To Protect and Promote the Health and the Environment of the People of Kittitas County

VA-23-00004 Kosar

Site Sketch / As-Built Drawing

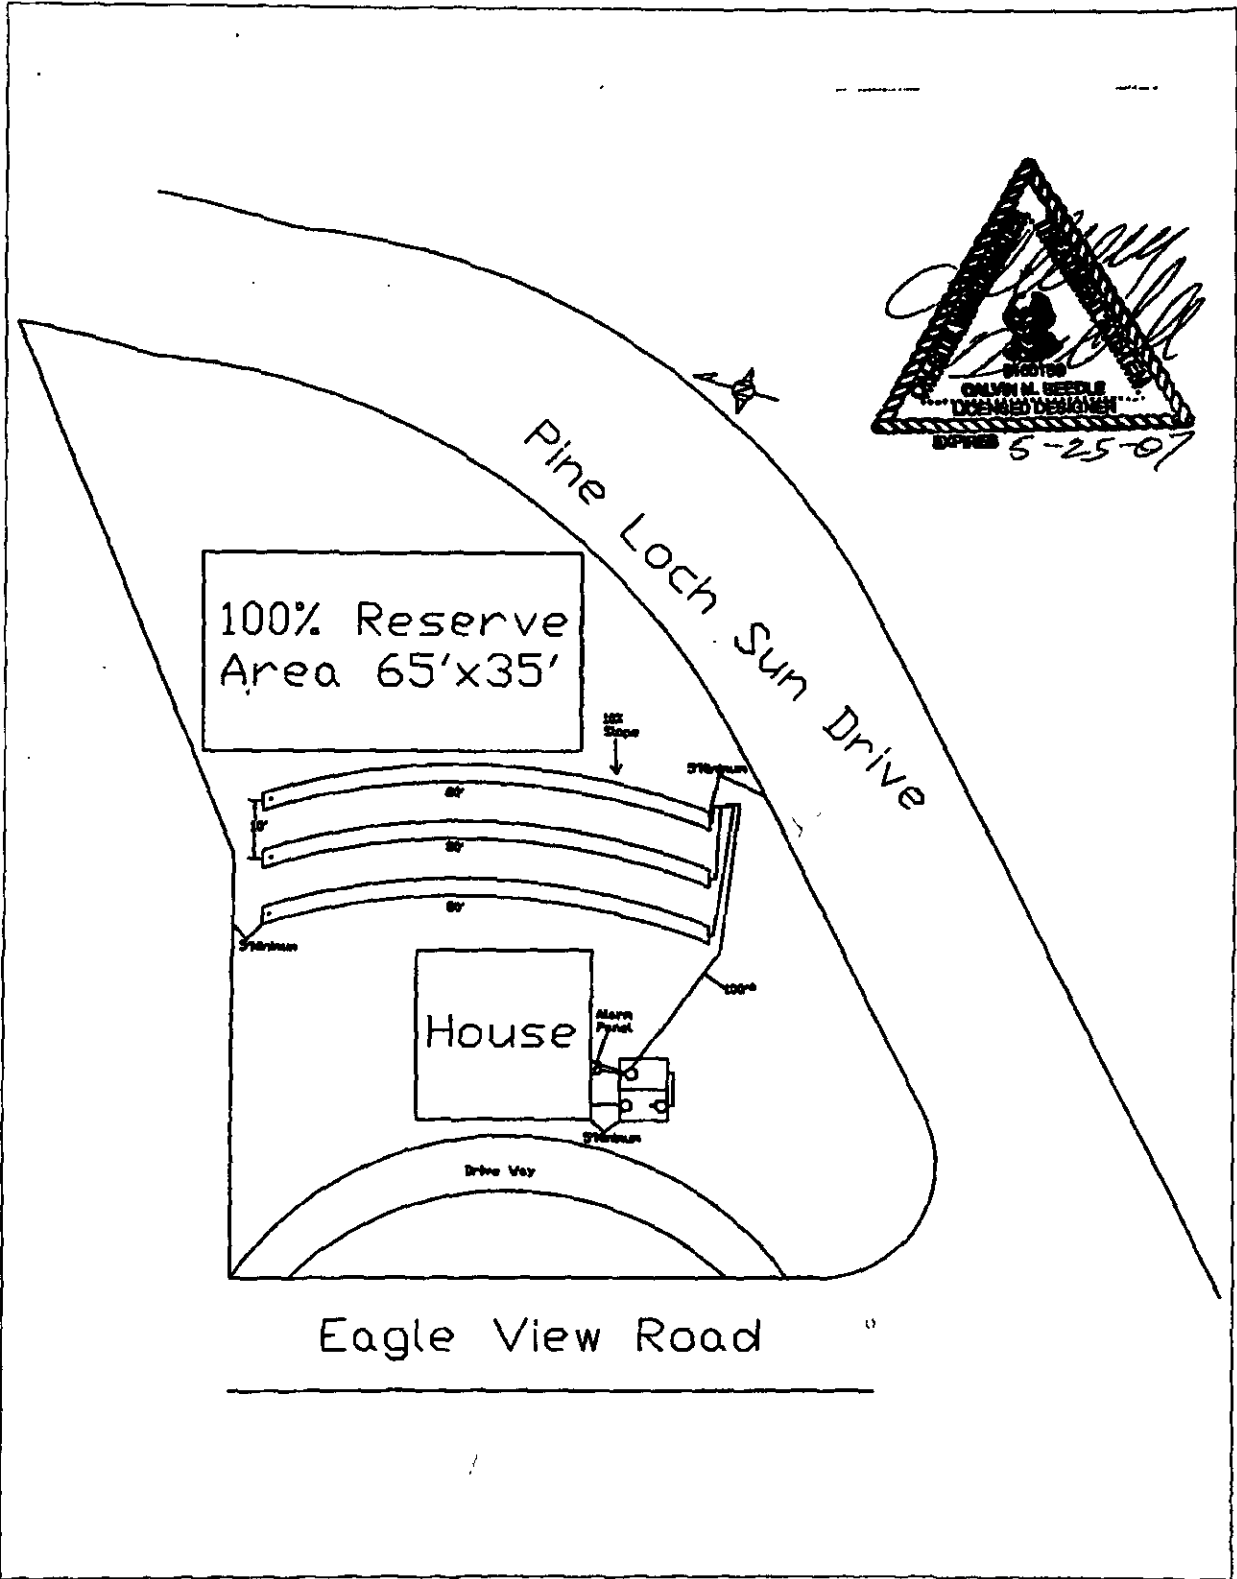
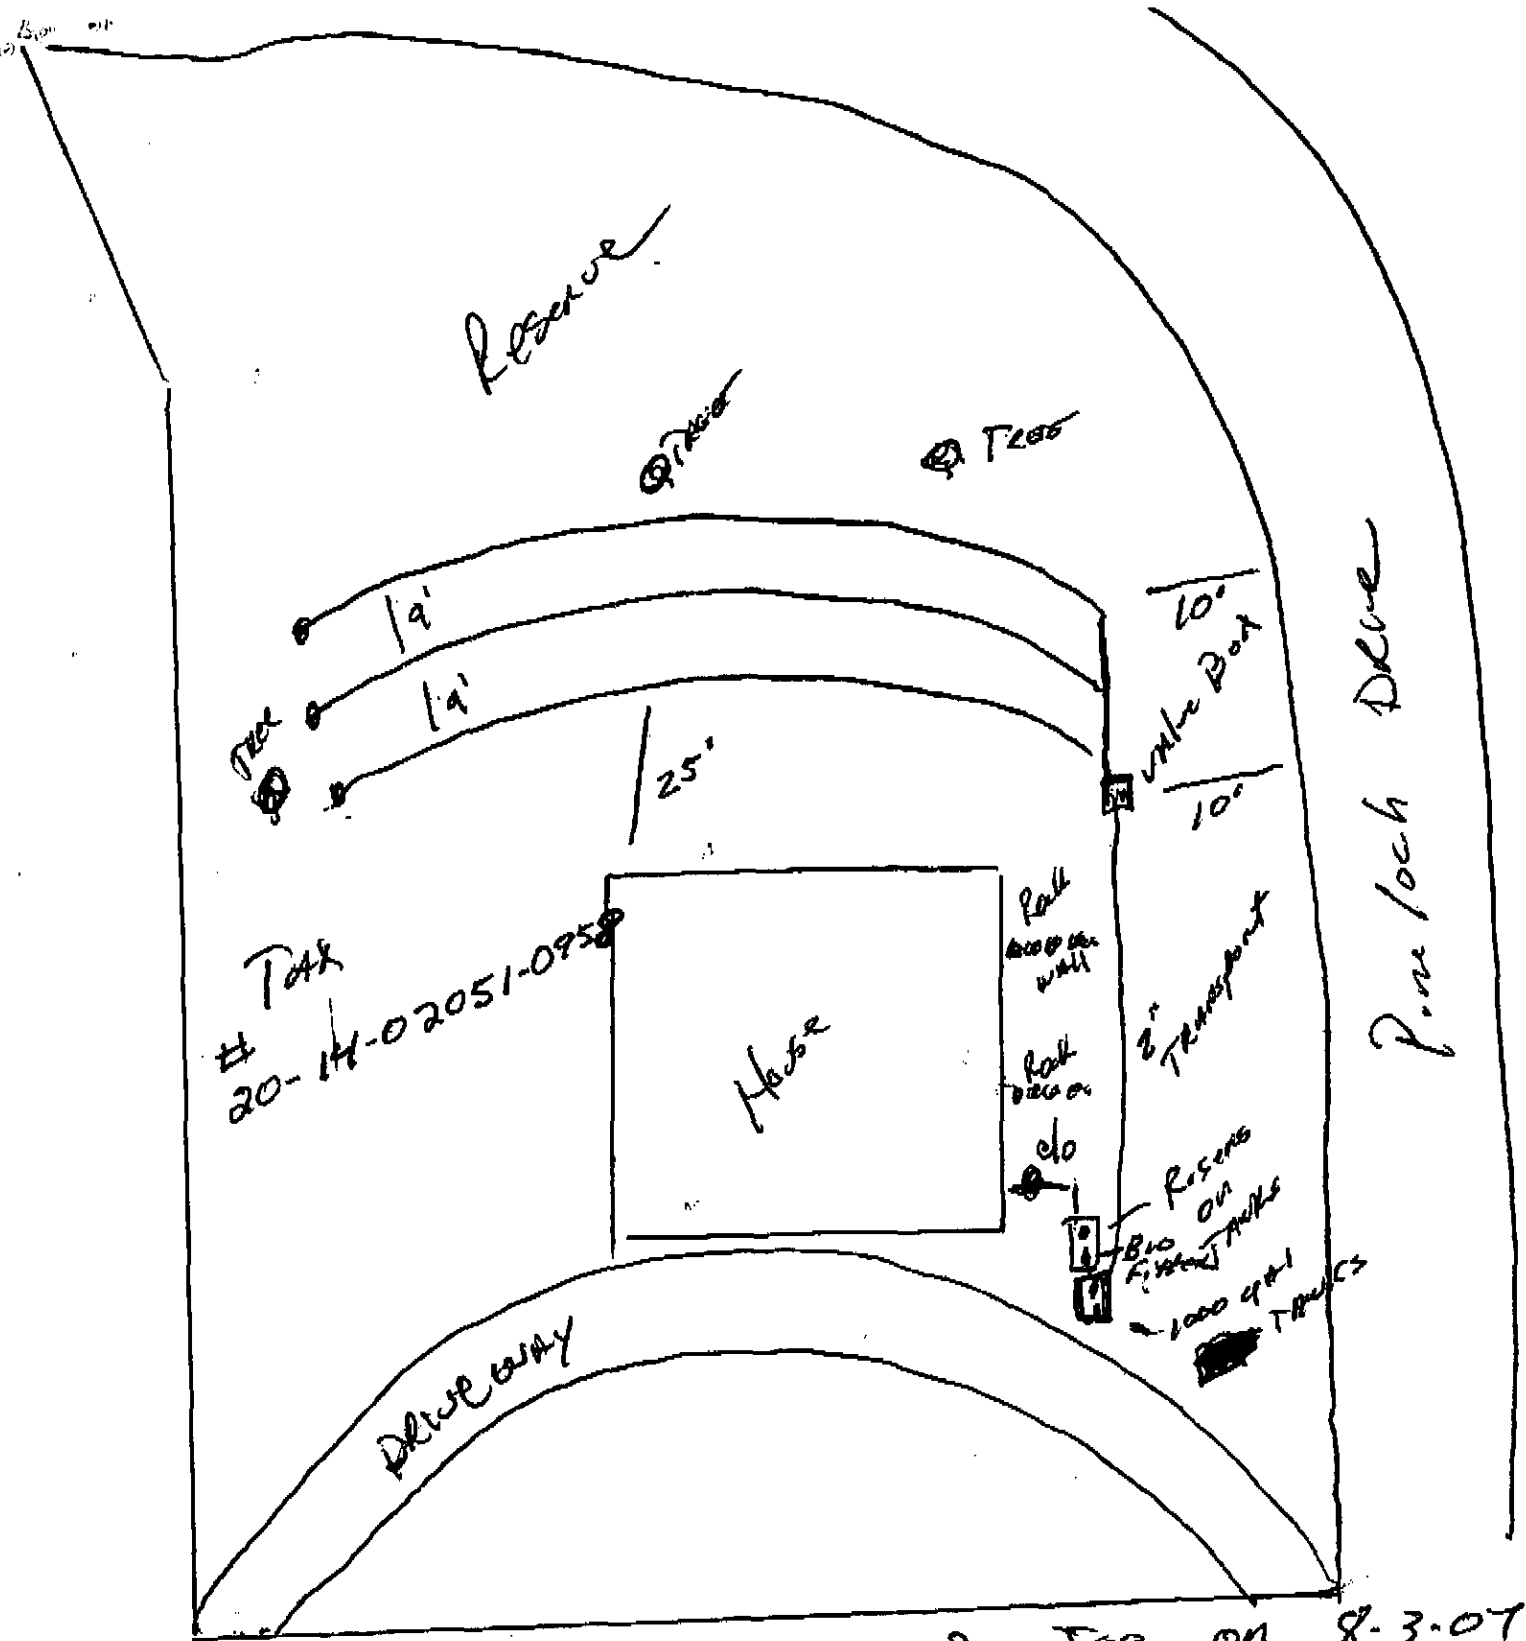
The current septic system and designed listed reserve area is where the proposed garage will be. KCC 13.04.080, requires that no impervious surface be placed above an on-site sewage disposal system or a reserve area.

The applicant will need to propose a smaller structure or a new location.
